November 11, 2021 2500 Carlisle TIS Review Comments and Responses

NM 299.03

Created By: W Marco Barraza

Figure 3. Existing (Adjusted) 2021 Turning Movement Counts

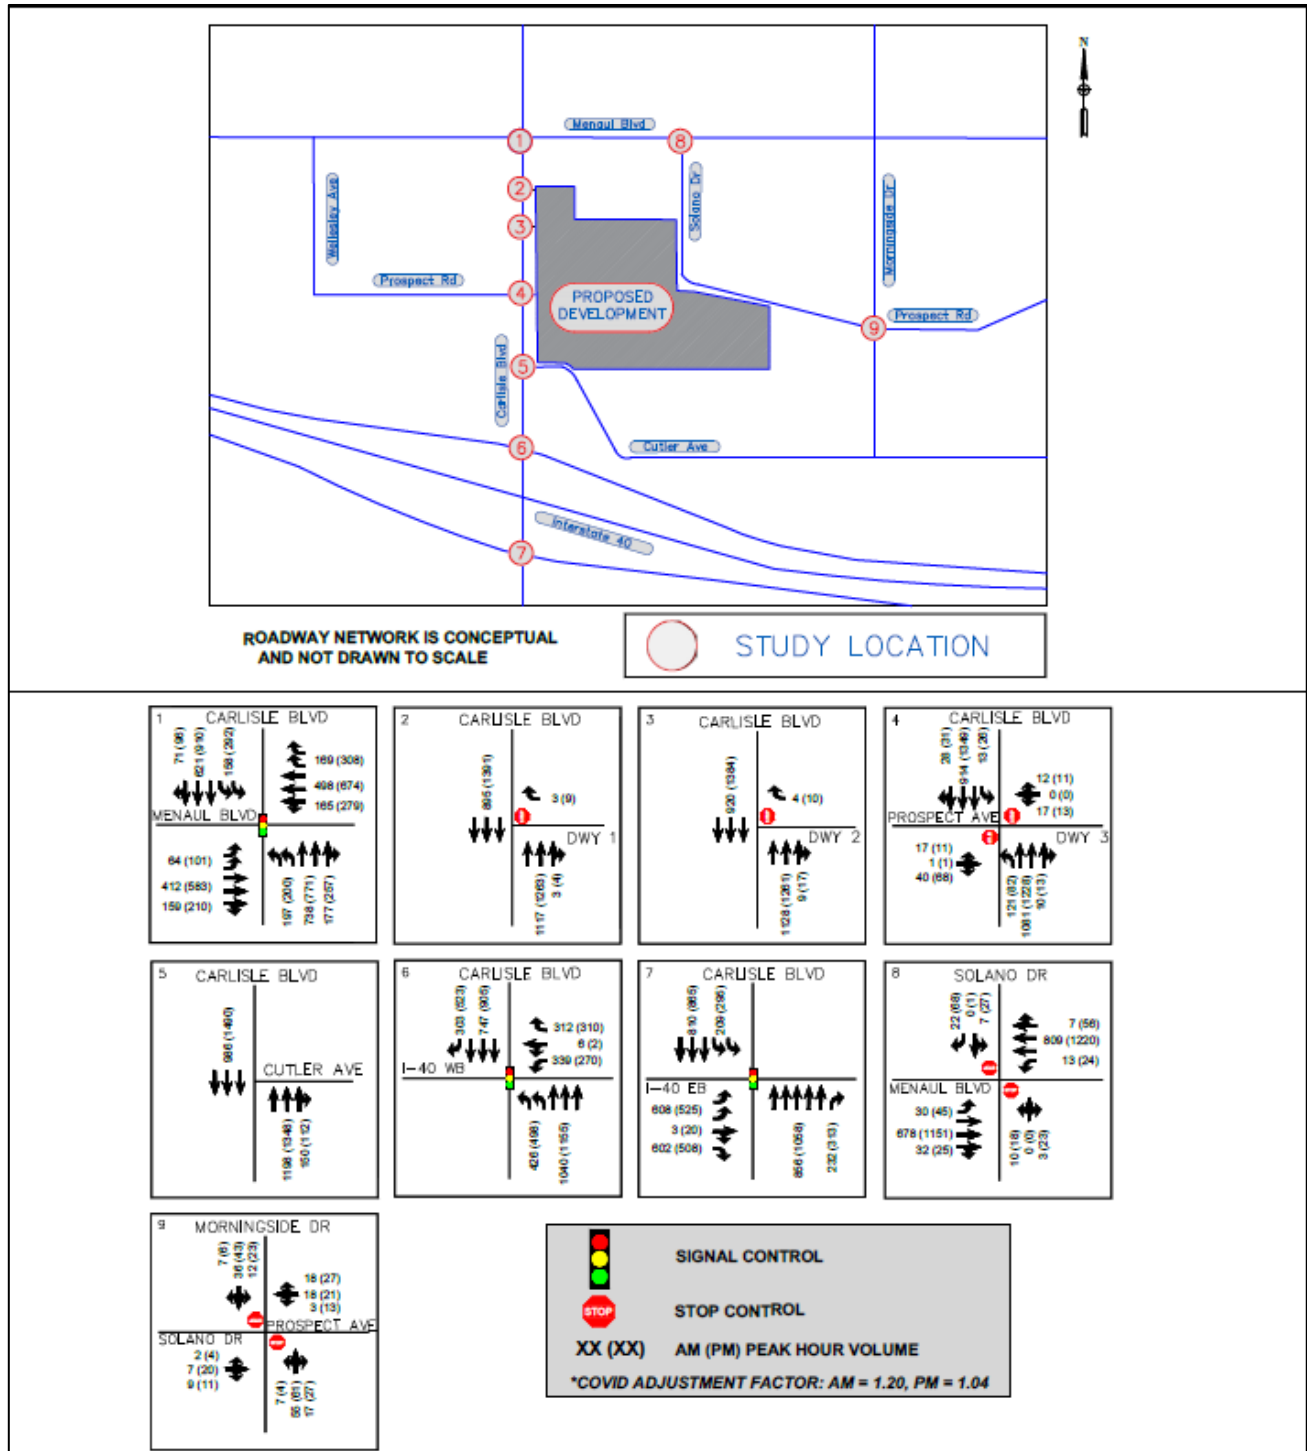
Lee Engineering		
Comment #	Page Number	Comment	Agency	Action Taken
1	-	The diagrams with turning moving count starting on page 8 are difficult to read. For future submittals please correct.	New Mexico Department of Transportation (NMDOT)	Accepted. Report figures were re-plotted with higher reso and inserted as PNG.
2	-	The site plan shows an existing access to Cutler, a one-way access to at Carlisle. NMDOT recommends additional wrong way and one way signage at this access. See exhibit to the right.	New Mexico Department of Transportation (NMDOT)	Accepted. Recommendation added to report (page 46): Developer should additional wrong way and one way sign Cutler access.
3	2	Label access points	New Mexico Department of Transportation (NMDOT)	Accepted. Updated Figure 1 to show access points.
4	13	It appears that the WBR existing storage use is 350-feet. How is this calculated when the striped lane is less than 200-feet?	New Mexico Department of Transportation (NMDOT)	Assumption of 350-feet is based on available "un-striped' storage length for WBR. This was based on how far back stop bar, 10-feet of roadway width is available. Per comm and the above measurement methodology on this measu the WBL queue storage was changed to 250-feet.
